**KIRKLEES METROPOLITAN COUNCIL
INVESTMENT & REGENERATION SERVICE**

**DELEGATED DECISION FOR APPLICATION FOR CERTIFICATE OF
LAWFUL DEVELOPMENT**

Reference no.: 2023/CL/92696/W

Site: 56, Greenhill Bank Road, New Mill, Holmfirth, HD9
1ER

Section C-C  
1 : 100

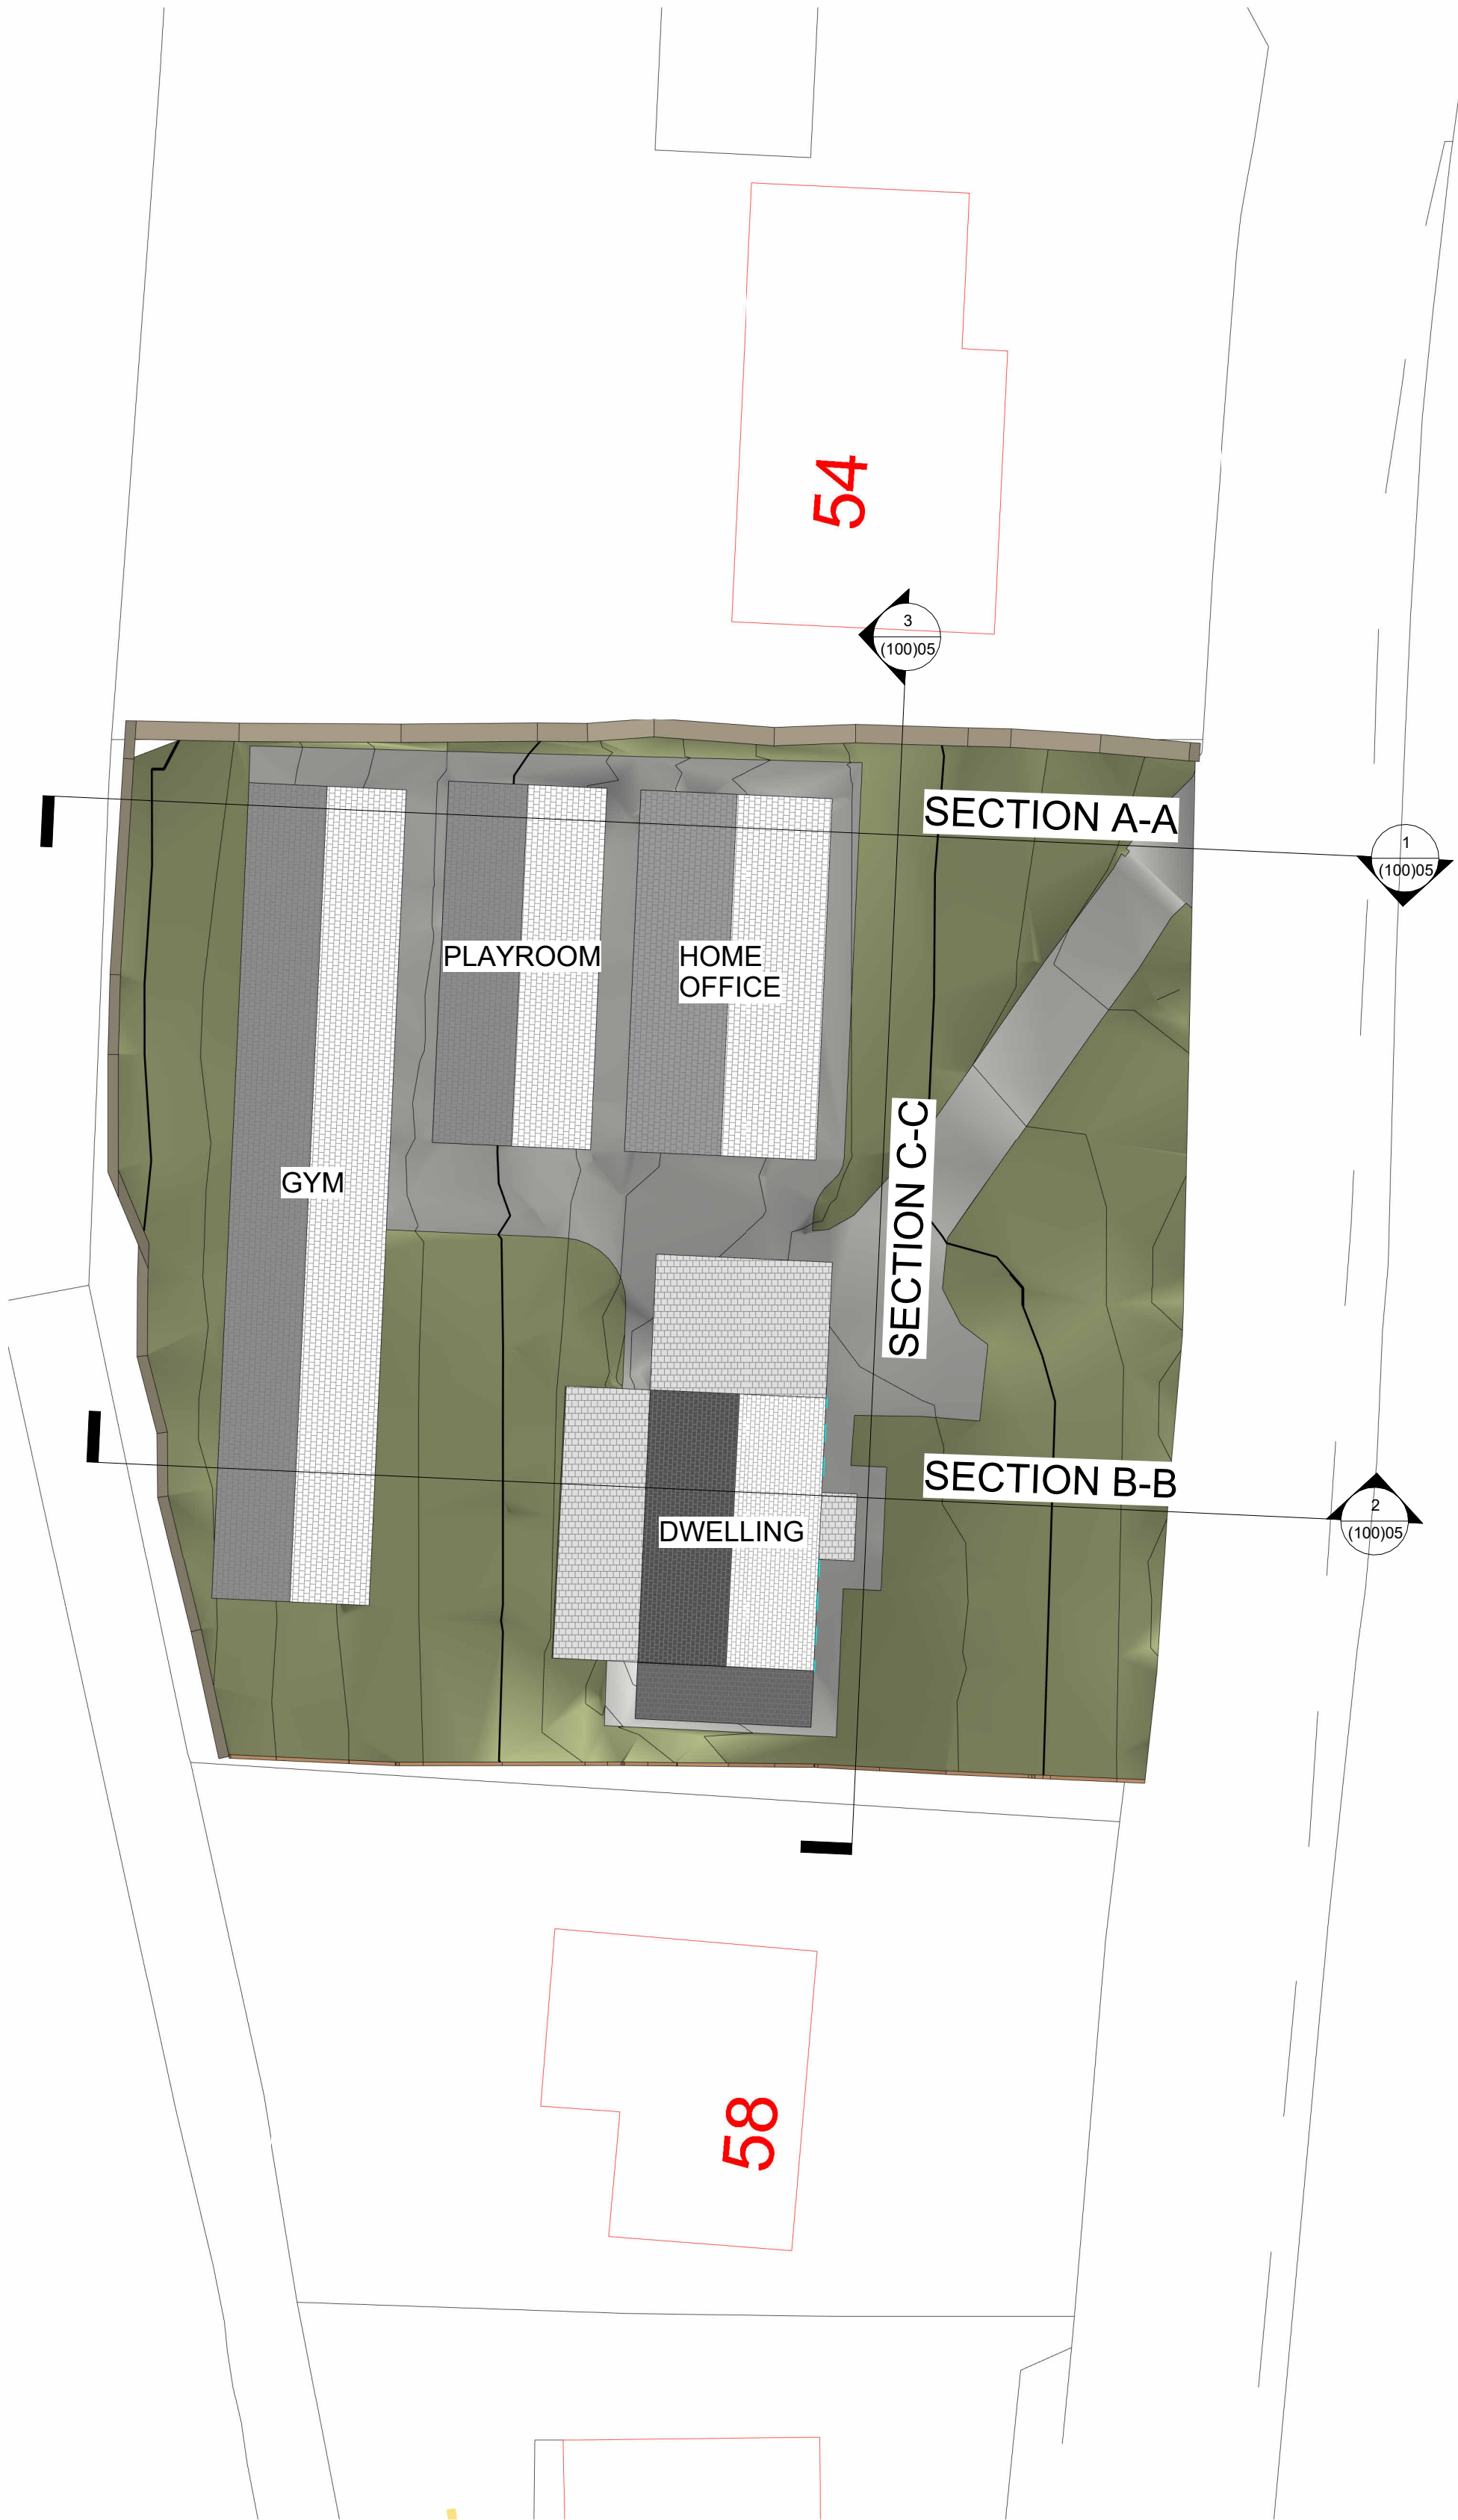
Comment: The submitted elevations show that all three outbuildings would be within these limits (when measured from the lowest ground level adjacent to the development as per the Technical Guidance).

Comment: The submitted elevations show that all three outbuildings would be within this limit (when measured from the lowest ground level adjacent to the development as per the Technical Guidance).
